Council Reference: D26/317990
Contact Person: David Zabell

27 July 2026

Shoalhaven Starches Expansion Project – MP06_0228-Mod-26
Bolong Road Bomaderry

I refer to the Department of Planning, Housing, and Infrastructure's request for comment in relation to Manildra MOD-26.

DRAWN	DATE	JOB TITLE	SHOALHAVEN STARCHES.BOMADERRY. NSW			SHT SIZE
P.C.	11/10/21					A3
CHKD	DATE	DWG TITLE	MOD 26.			REV.
T.J.			O/A WESTERN SITE PLAN.			
APPD	DATE	PROJECT No.	7549SITE	DWG No.	MN7549-002	P21
	SCALE		1:2500

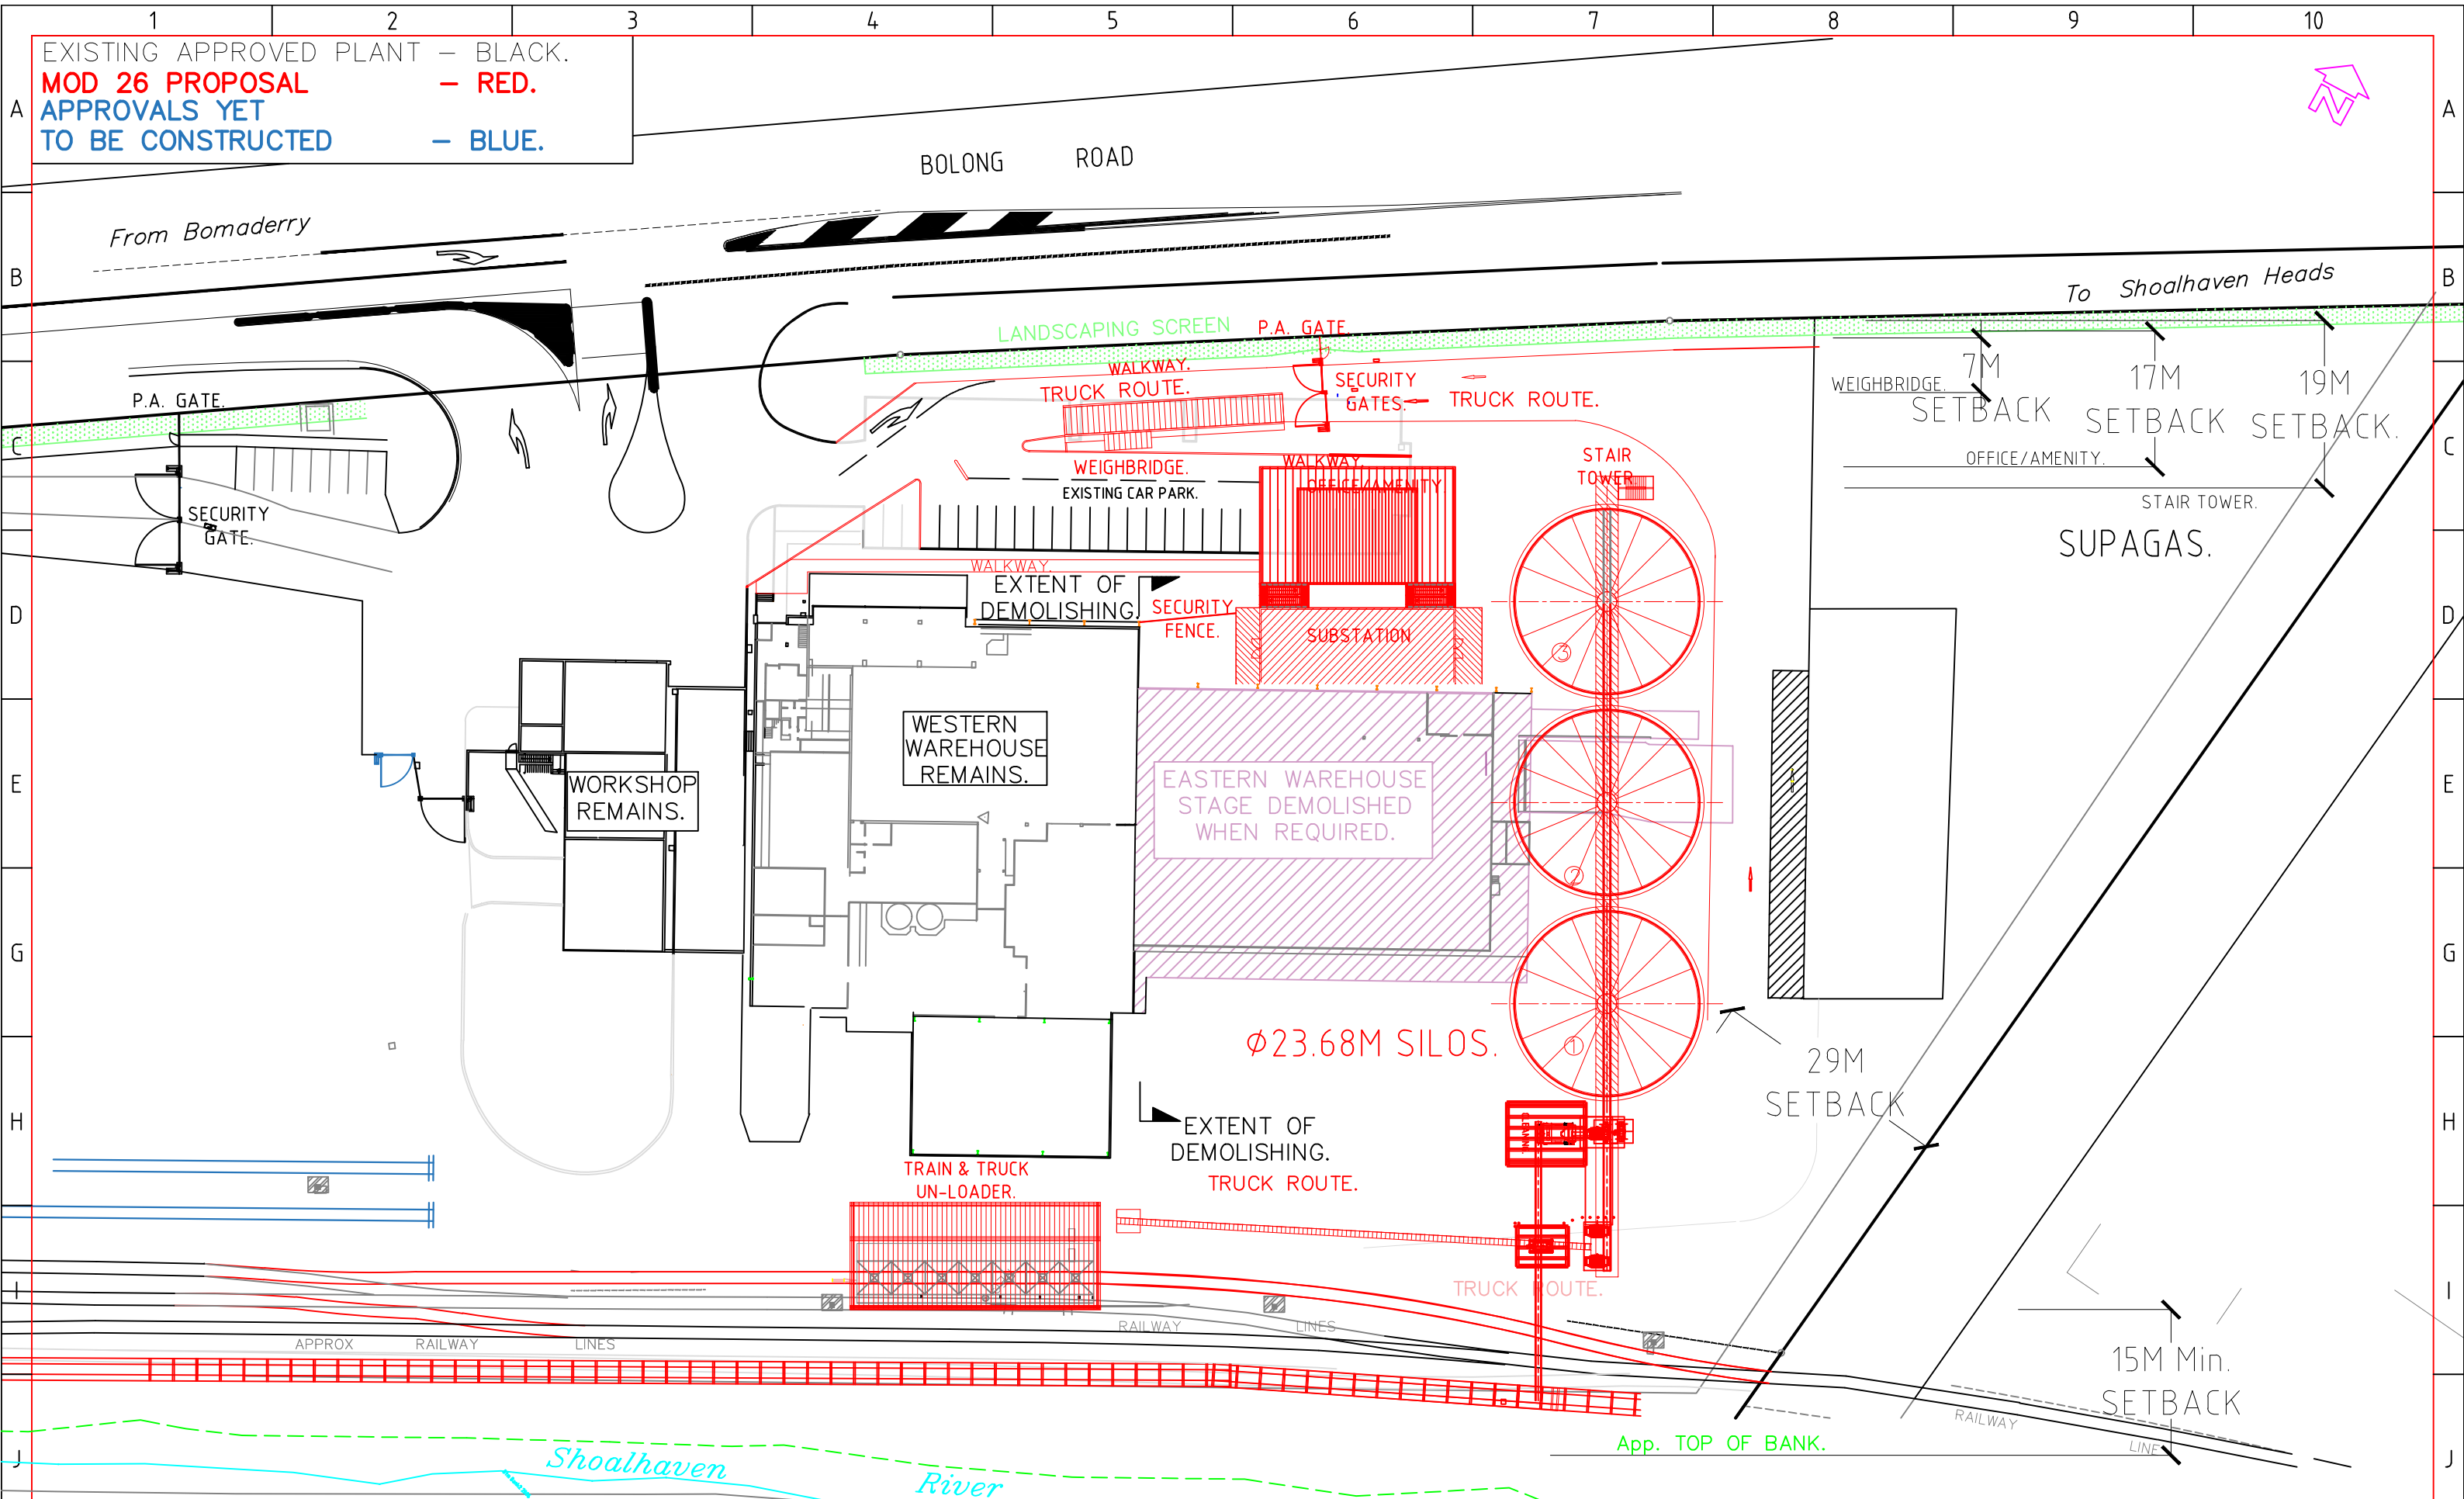
- The proposed substation building will also be a fire source feature to the existing warehouse buildings. The construction of the substation adjoining an existing warehouse would usually require investigation and/or implementation of fire safety upgrading to the existing building. The eastern and western warehouses are a single building on the site plan and upgrading must consider the entire building.

- The site plan notes that the eastern warehouse will be ‘demolished when required’ and it appears that at least a portion must be demolished for the proposed silo construction. Part 6.1 of the Modification Report indicates that the demolition will be required to construct the silos and the substation building.

- The use of ‘when’ and ‘as required’ does not provide any definitive outline for the demolition. It is unknown whether a part of the existing eastern warehouse could be demolished to permit the proposed silo construction and maintain its structural adequacy. If the existing building can accommodate partial demolition, the silo construction will not create a fire source feature to the existing warehouse building. *It is recommended* that a condition is placed in a modified consent requiring the eastern warehouse building to be demolished prior to the issue for a CC for the proposed

substation building. This would remove the need for fire safety upgrading (and the associated cost) on a building which is to be demolished at some point in the future.
